A47 North Tuddenham to Easton Dualling

Volume 2 **2.12 Hedgerow Plans**

The A47 North Tuddenham to Easton
Development Consent Order 202[x]

Version	Date	Status of Version
Rev. 0	March 2021	Application Issue
Rev.1	October 2021	Deadline 3 Issue
Rev.2	December 2021	Deadline 6 Non-Material DCO Change Request
Rev.3	January 2022	Deadline 8 Update
Rev.4	February 2022	Deadline 9 Update

DRAWING NUMBER
HE551489-GTY-LSI-000-DR-CH-40014

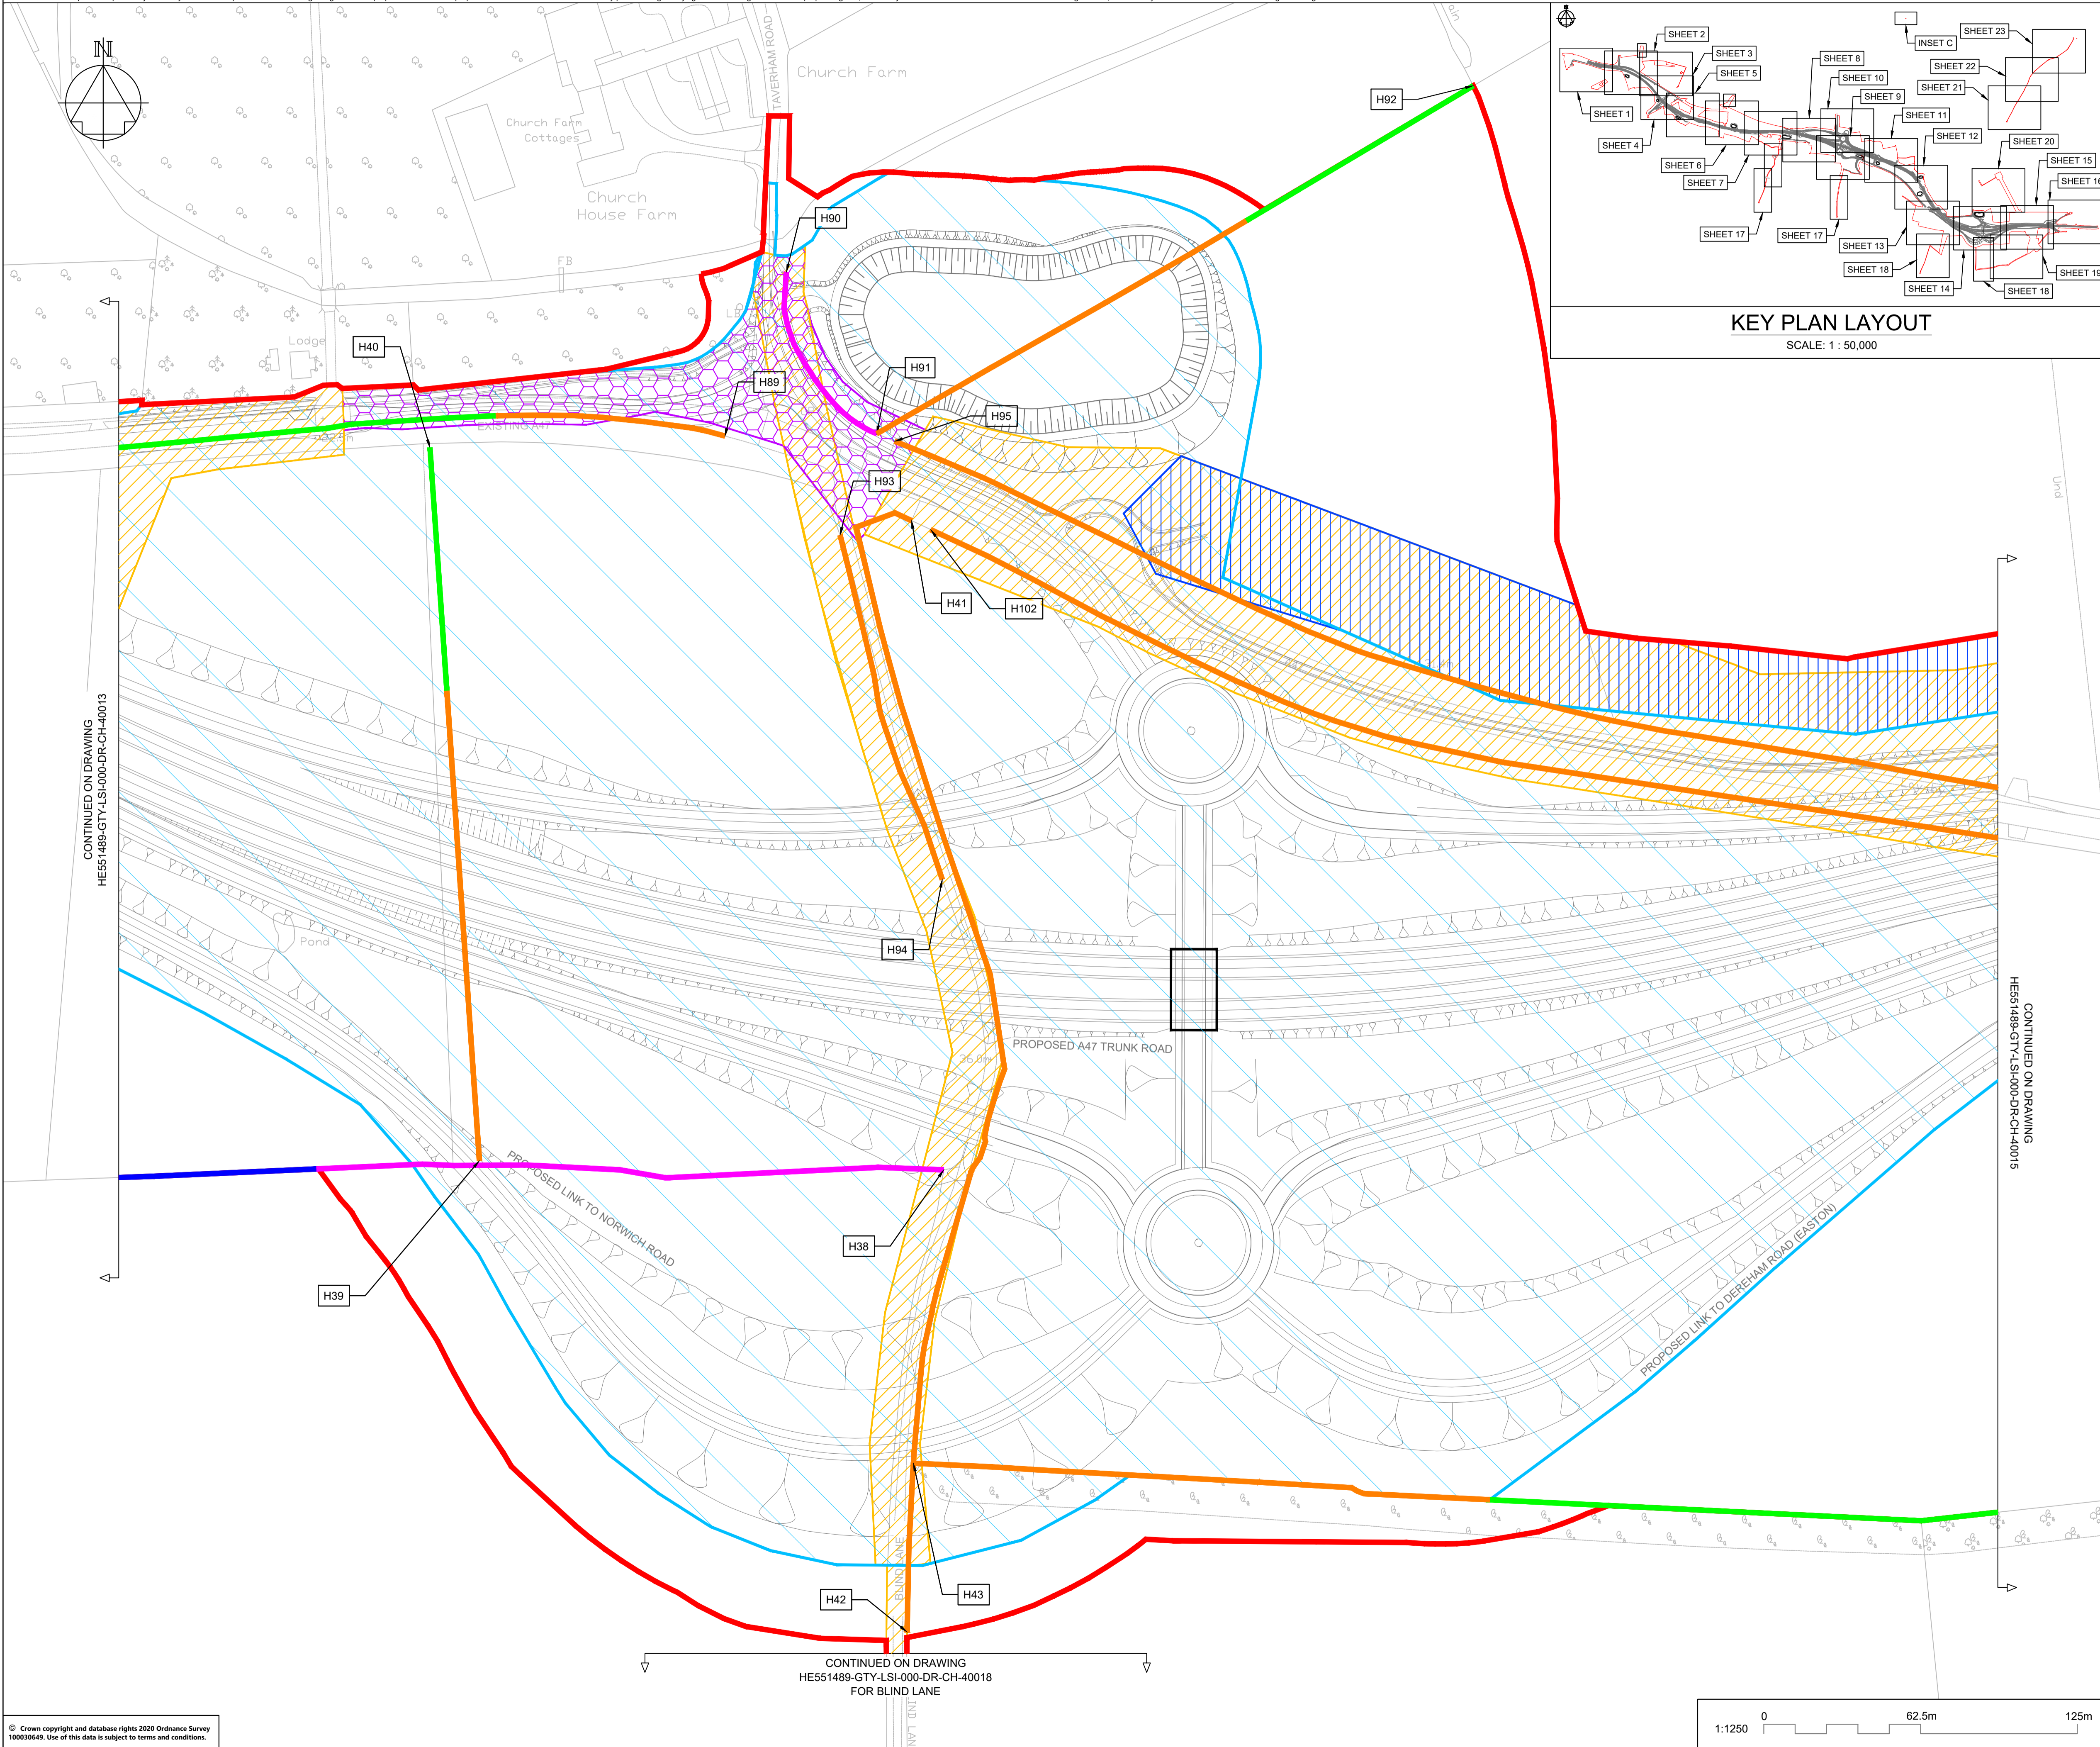
- 2.1.1 The Key Plan and drawing sheets 9 and 14 have been updated to reflect the below changes to the Scheme design. The changes to the design and limits of deviation all remain within land allocated for permanent acquisition to deliver the Scheme:
- Alteration of the proposed existing A47 and realigned Taverham Road junction to remove any permanent works within land parcel 14/6a, in response to commitments in RR-006, RR-006 and RR-006 in the Applicant’s Responses to the Relevant Representations (**REP1-013**).
 - Illustrate the change between the 3m wide RB1 byway connection to a 2m wide cycle only along the south side of the existing A47, in response to commitments in RR-037.59 in the Applicant’s Responses to the Relevant Representations (**REP1-013**).

- 3.1.1 The Key Plan and drawing sheets 2, 4, 9 and 14 have been updated to reflect the following changes proposed in the Non-Material DCO Changes Request (**TR010038/EXAM/9.26**) submitted to the Examining Authority:
- Relocation of Lyng Road drainage basin access track.
 - Alteration to the existing A47 and Mattishall Lane Link Road junction to allow a ghost island.
 - Alteration of the existing A47 and Dereham Road junction to allow a ghost island, with associated alteration to the adjacent drainage basin and its access track.
 - Adjusted Berrys Lane highway limit of deviation for the proposed drainage along Berrys Lane, and amend the material storage area north of Berry Hall.
 - Adjusted the highway limit of deviation for Taverham Road drainage basin to support inclusion of a wetland area.
